Department of Planning and Environment

Our ref: DOC22/307734
Your ref: SSD 11429726

Subject: Response to additional information - Eden Street, Arncliffe Mixed Used Redevelopment

Figure 1: Root investigation near Tree 109 and two exposed roots. All levels located between the exploratory trench and site boundary to be retained and protected (green hatch).

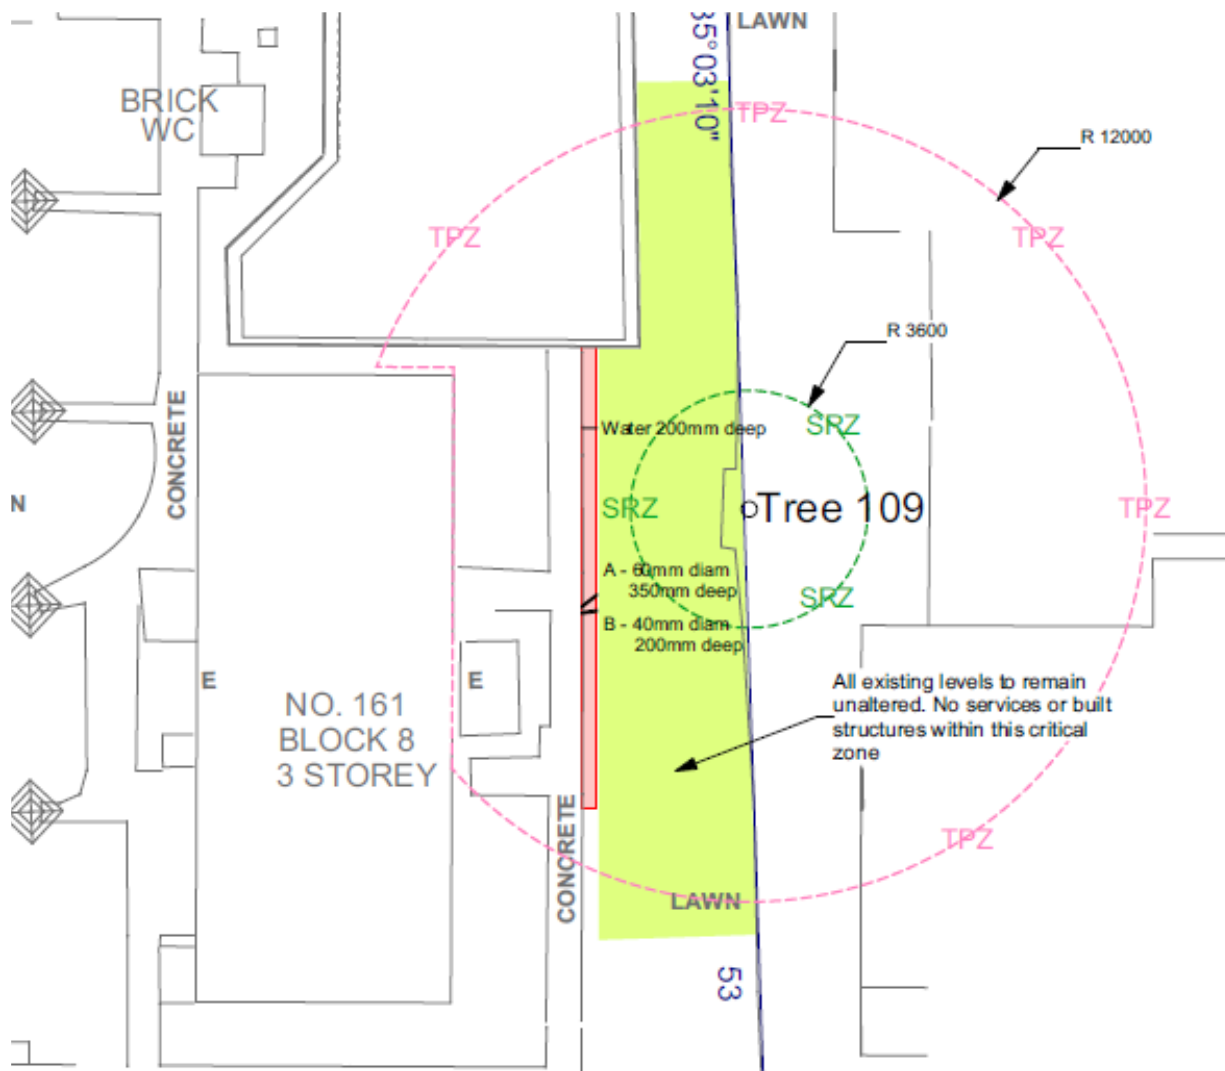
Amended landscape and architectural designs have been provided which respond to the recommendations for the protection of tree 109 as detailed in the Arboricultural Impact Assessment prepared by Birds Tree Consulting dated 22 December 2022.

EHG is satisfied that residual impacts to tree 109 can be managed through conditions of approval and that impacts from the proposed development are consistent with the Biodiversity Development Assessment Report Waiver that has been issued for the proposal. The following conditions of approval are recommended.

- Works within the Tree protection Zone of tree 109 are to be limited to those identified within landscape drawings 180913-DA 9509[6] prepared by Group GSA. A project arborist (AQF level 5 arborist) is to be on site to supervise any excavation within the tree protection zone of tree 109. If tree roots are identified and root pruning is necessary, all cuts should be clean cuts using sharp tools such as secateurs, pruners, handsaws, chainsaws or specialised root pruning equipment. All root pruning must be done in accordance with Section 9 of Australian Standard 4373-2007 Pruning of Amenity Trees.
